M3 Junction 9 Improvement

Scheme Number: TR010055

8.16 Applicant Comments on Deadline 3 Submissions

18 August 2023

**FIGURE 9A**  
*Environmental Masterplan & LVIA Viewpoints*

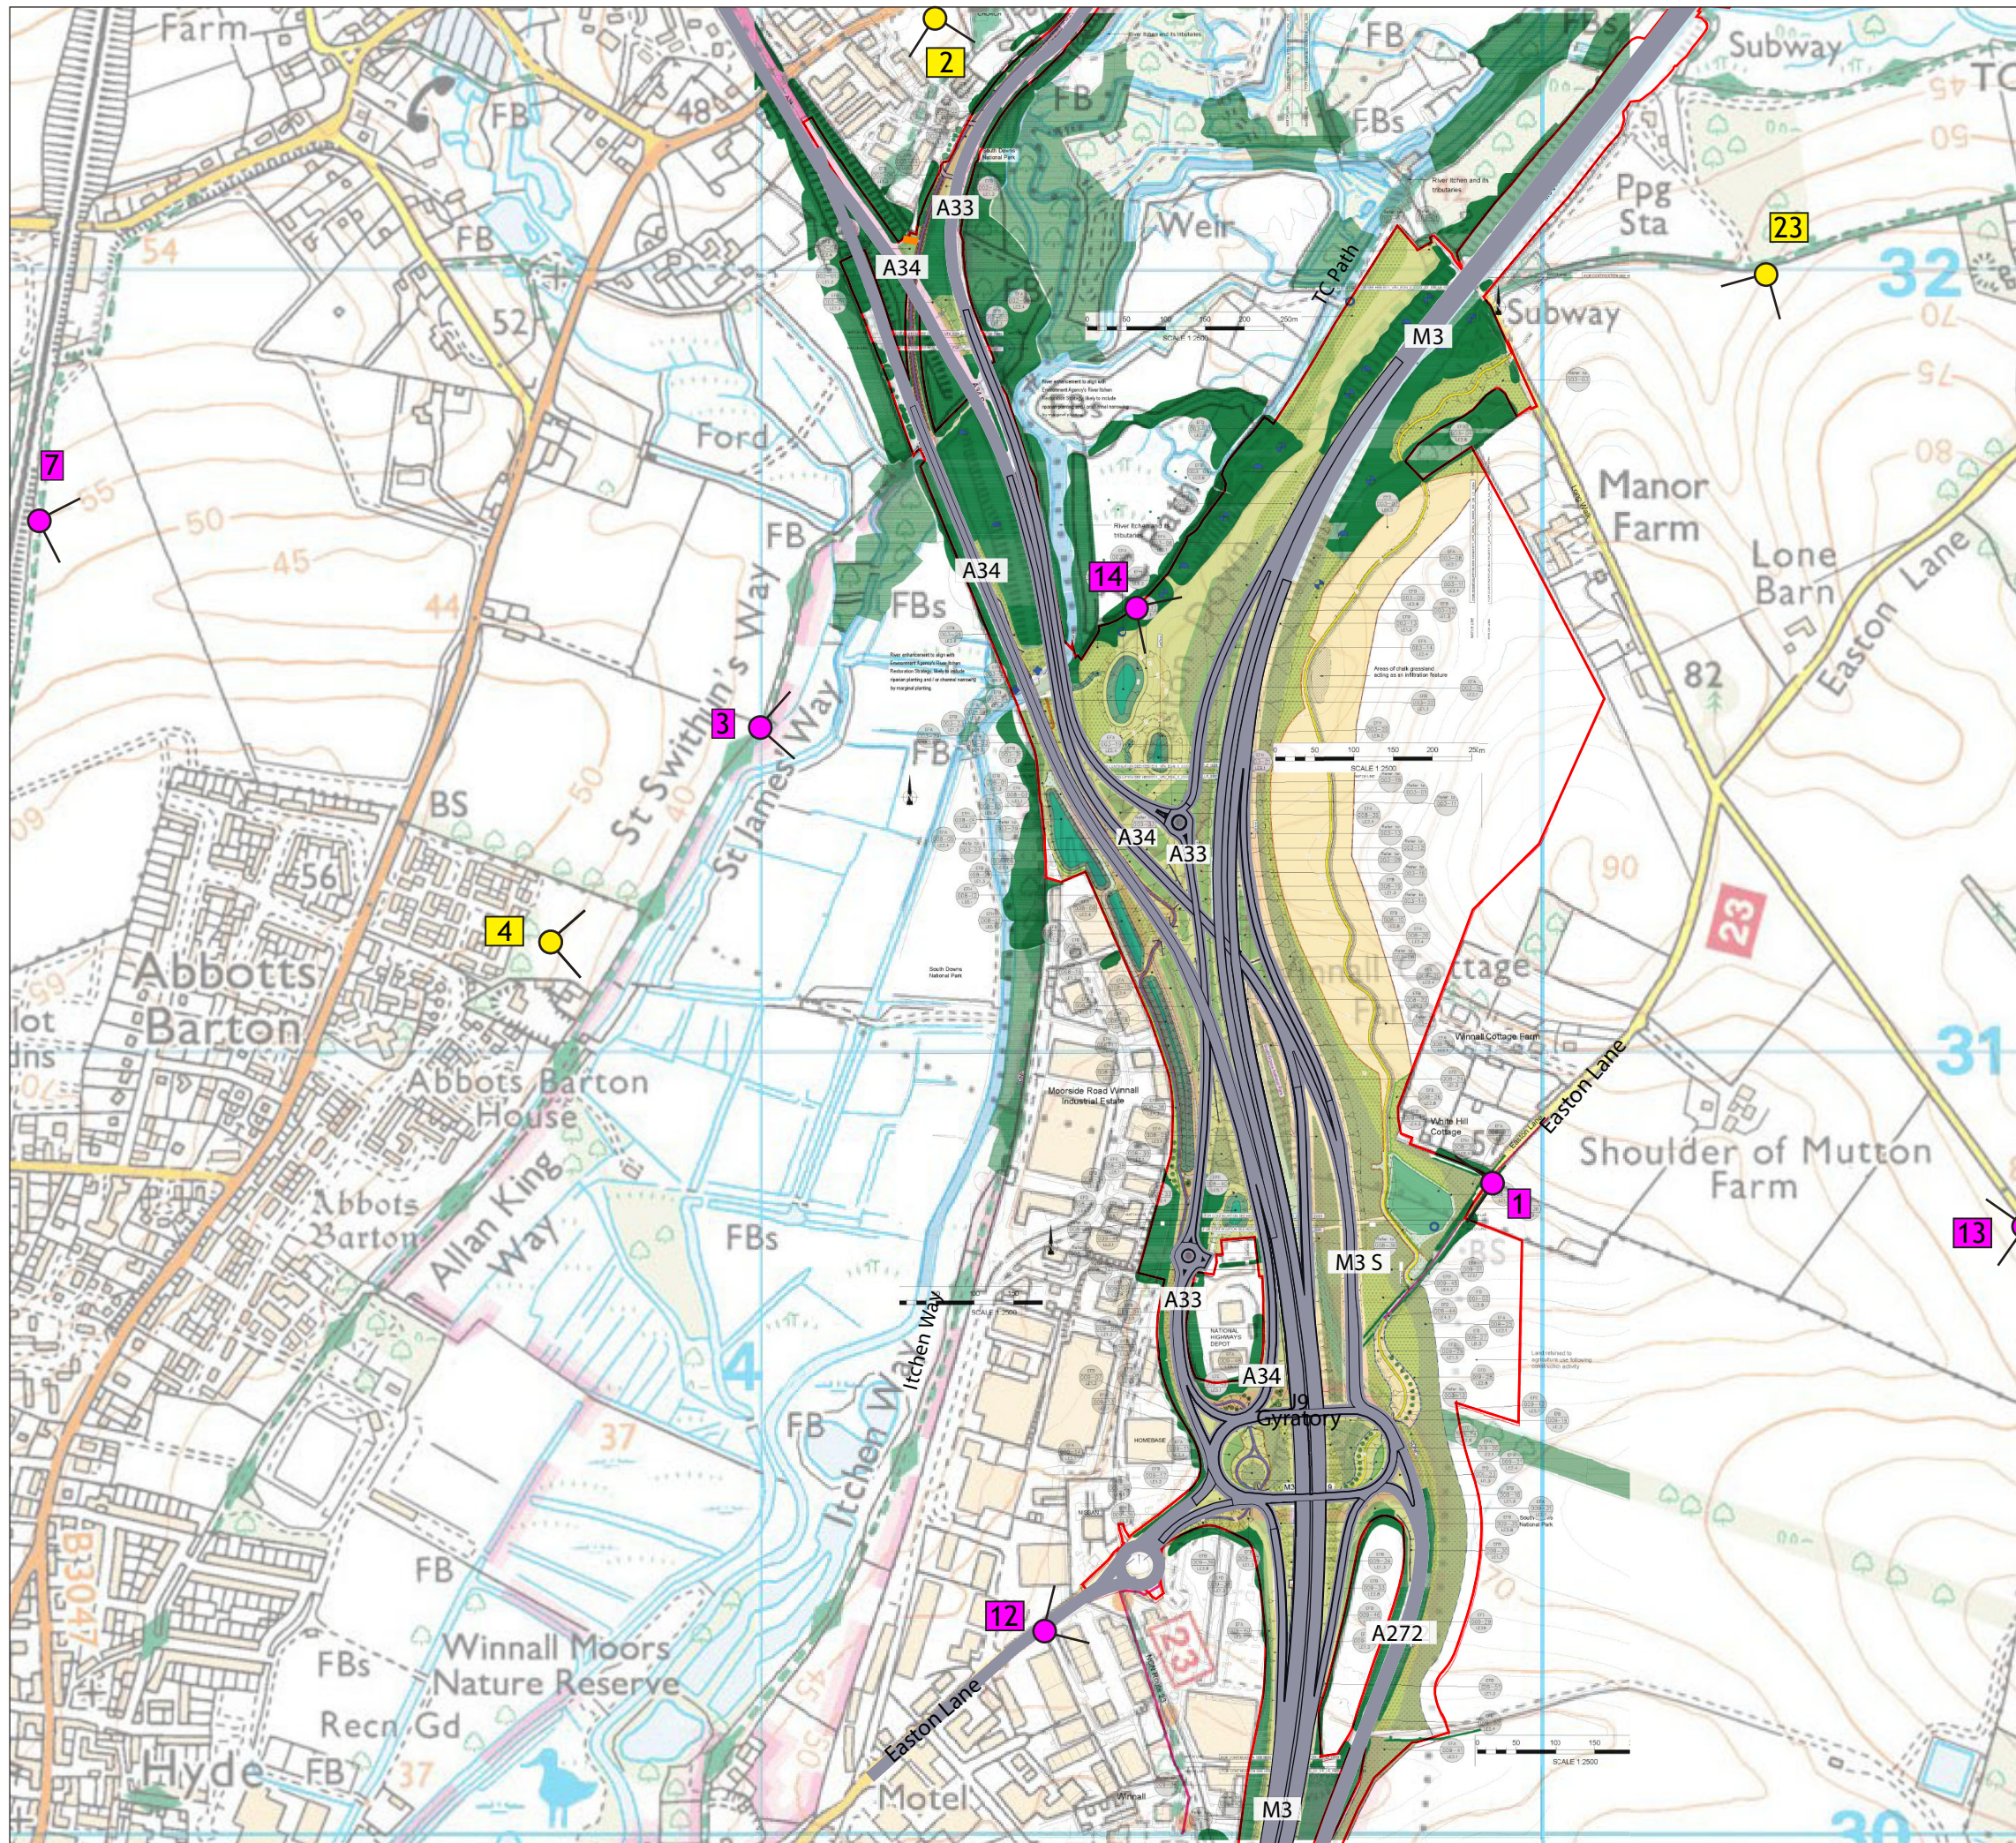
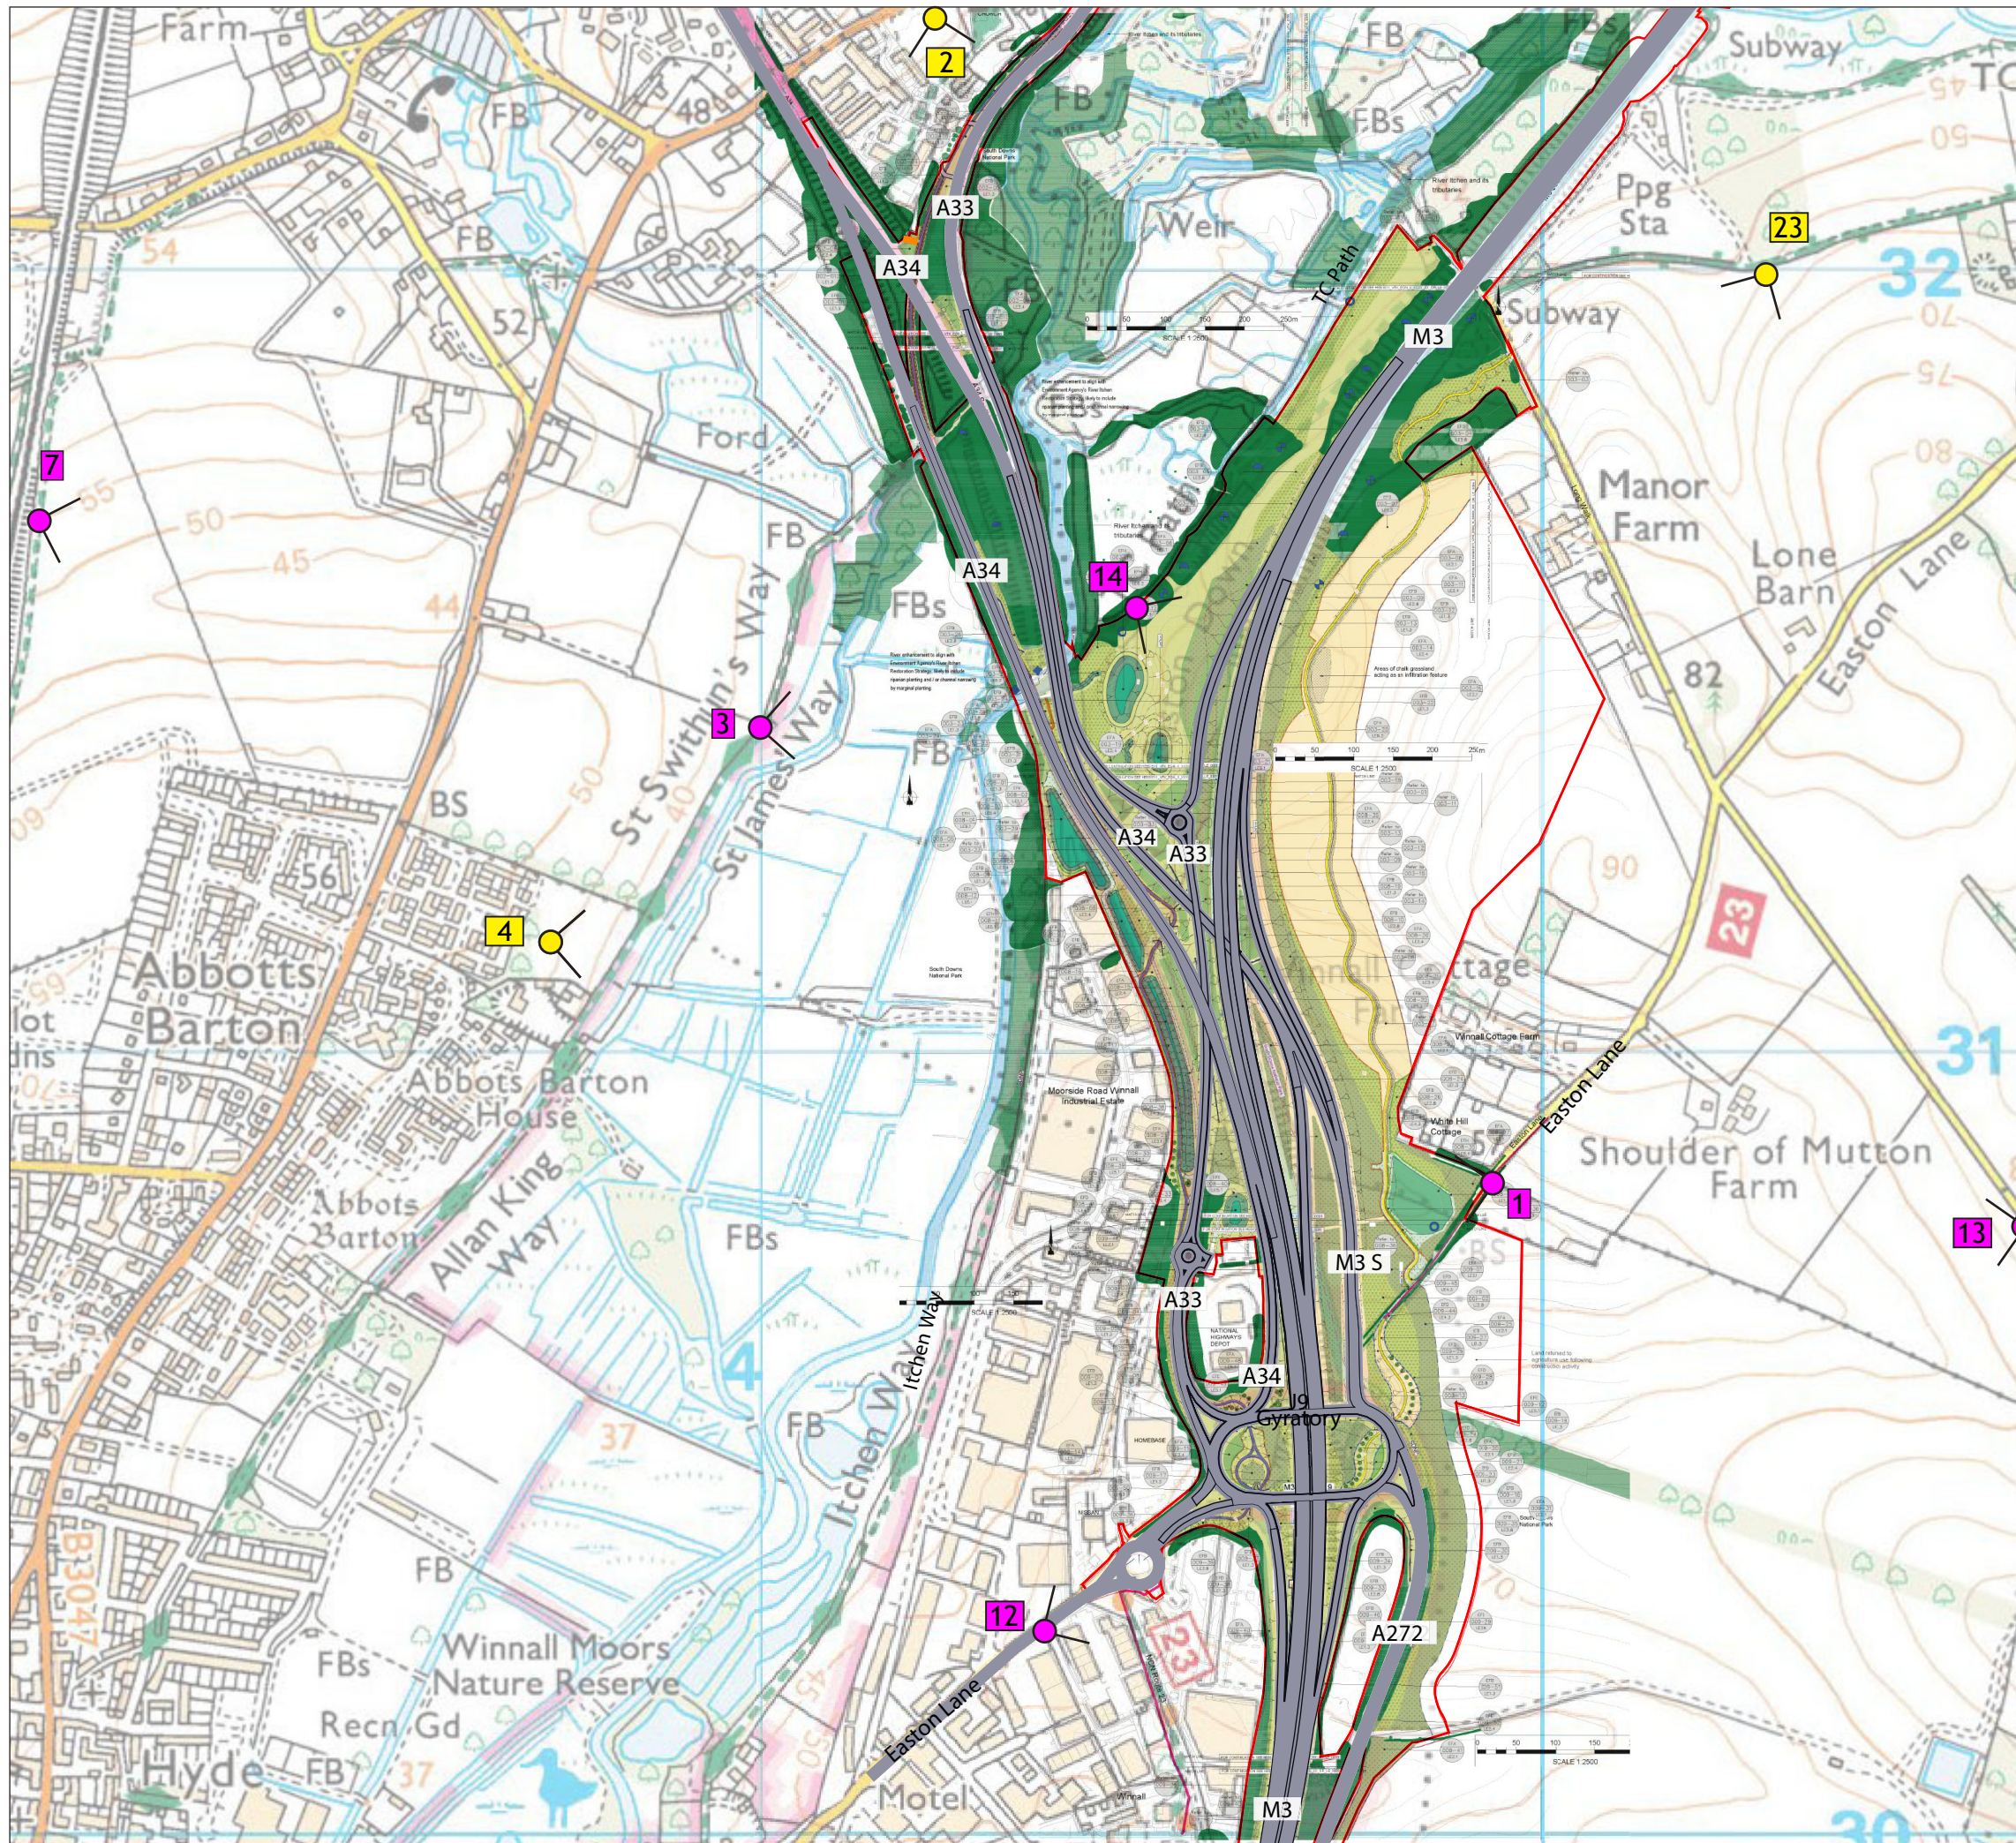
Twyford Parish Council	Applicant Response
	<p>Appendix 7.5 (Preliminary Arboricultural Impact Assessment) of the ES (6.3, APP-101). The Applicant has no further comments.</p>
<p>Figure 9A – Environmental Masterplan and LVIA Viewpoints</p>	<p>The Applicant notes that this is a figure produced by South Downs National Park Authority using information from Figure 2.3 in Chapter 2 (The Scheme and its Surroundings – Figures (Part 2 of 4)) of the ES (6.2, APP-062). The Applicant has no further comments.</p>
